Sent: 26 September 2012 12:36
To: Aahsanur Rahman; Planning
Subject: Re planning application for 35 Sherrards Park Road - ref N6/2012/1688/EP

- We note Mr Moody's comments about amending the plan to encompass a non-opening obscured roof dormer window.
- We are not sure of the relevance of the photograph of number 39 Sherrards Park Road supplied by Mr Moody. The dormer windows on that property have an aspect only of the garden of that property and nothing else. It is not at all comparable with the proposed dormer window for number 35 which would look directly on to our garden and terrace. Number 39 is parallel to us whereas number 35 is at 90 degrees. As we explained in our letter of 3 September, the proposed dormer window at number 35 totally invades our privacy. We would respectfully request that a site visit be arranged so that the view from our garden can be seen.

PROJECT	35 Sherrards Park Road
DRAWING TITLE	Proposed Elevations
STATUS	Planning
SCALE 1:100 @ A3	DRAWN BY AM 08-004P

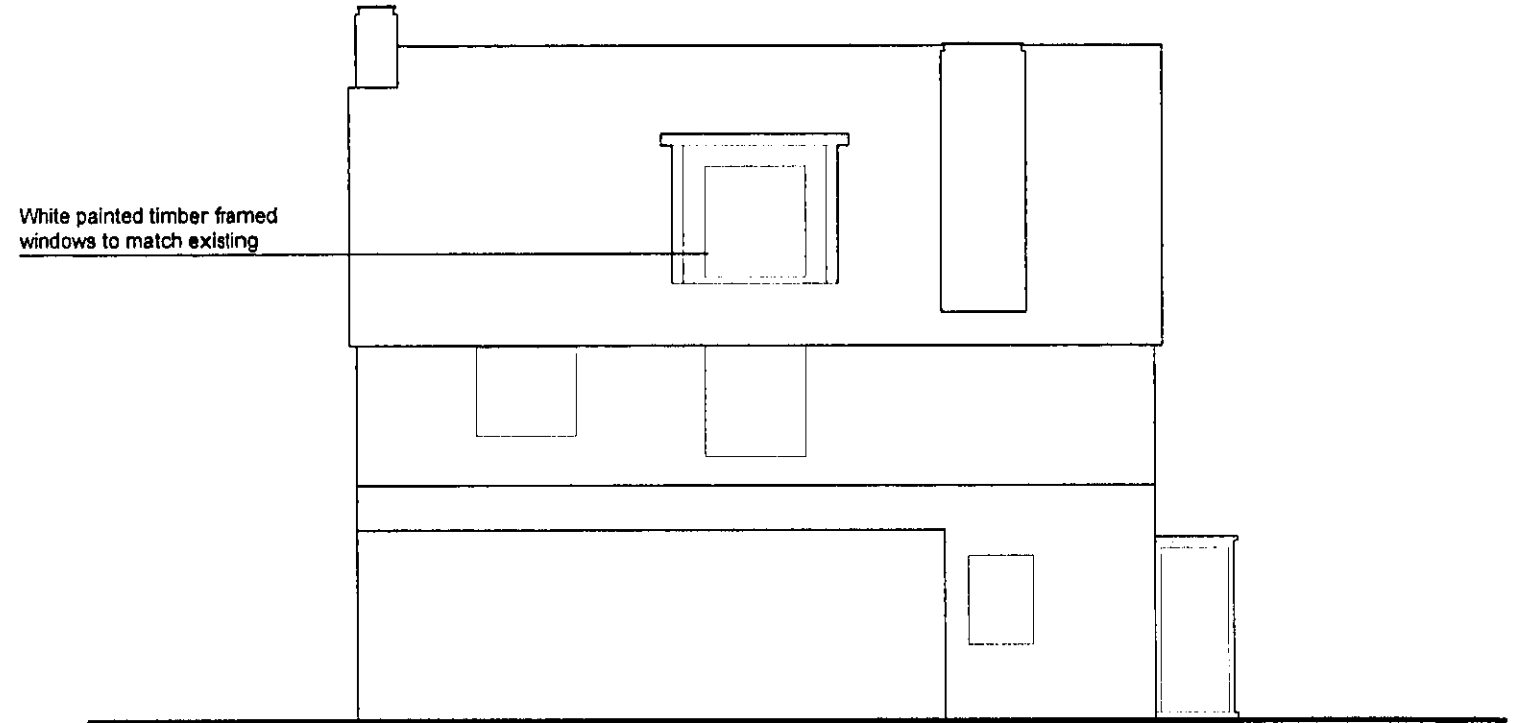
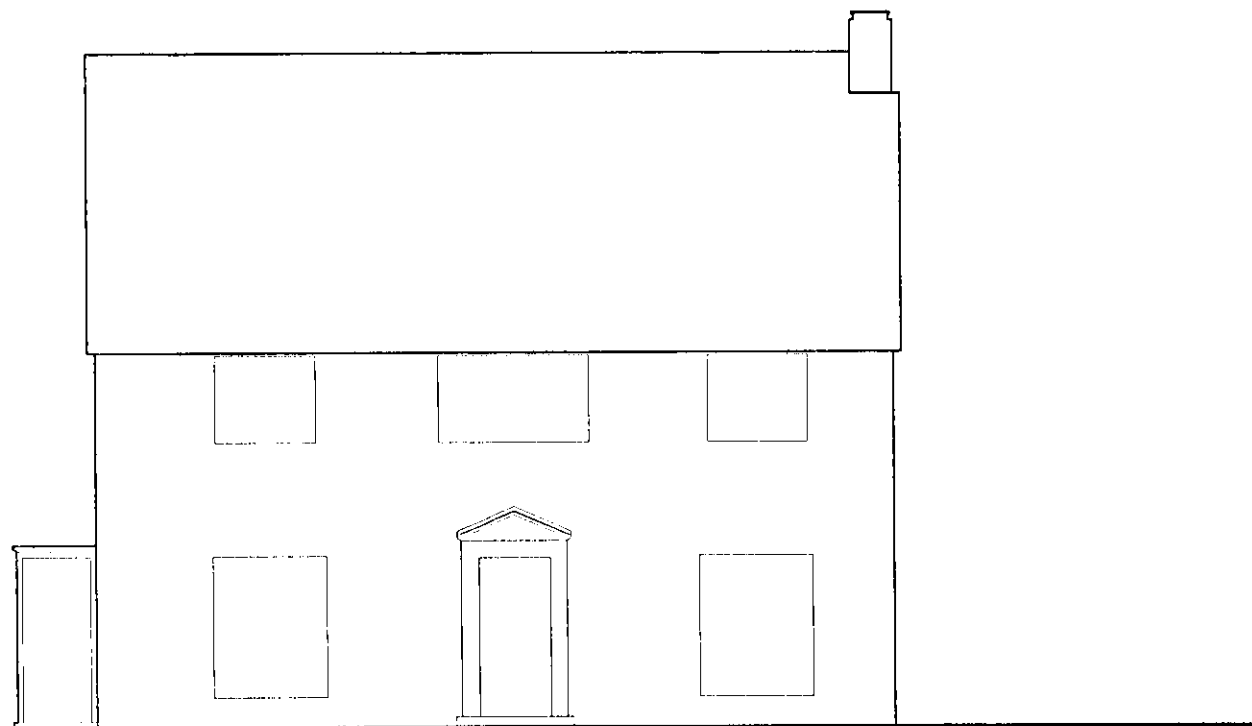
- We think that it would be far more appropriate if the proposed window was a velux window, which would maintain our privacy and be in keeping with the neighbourhood. In addition to the references to failed applications for roof dormer windows set out in our letter, we understand that a similar application from number 45 Sherrards Park Road was recently rejected due to privacy issues.
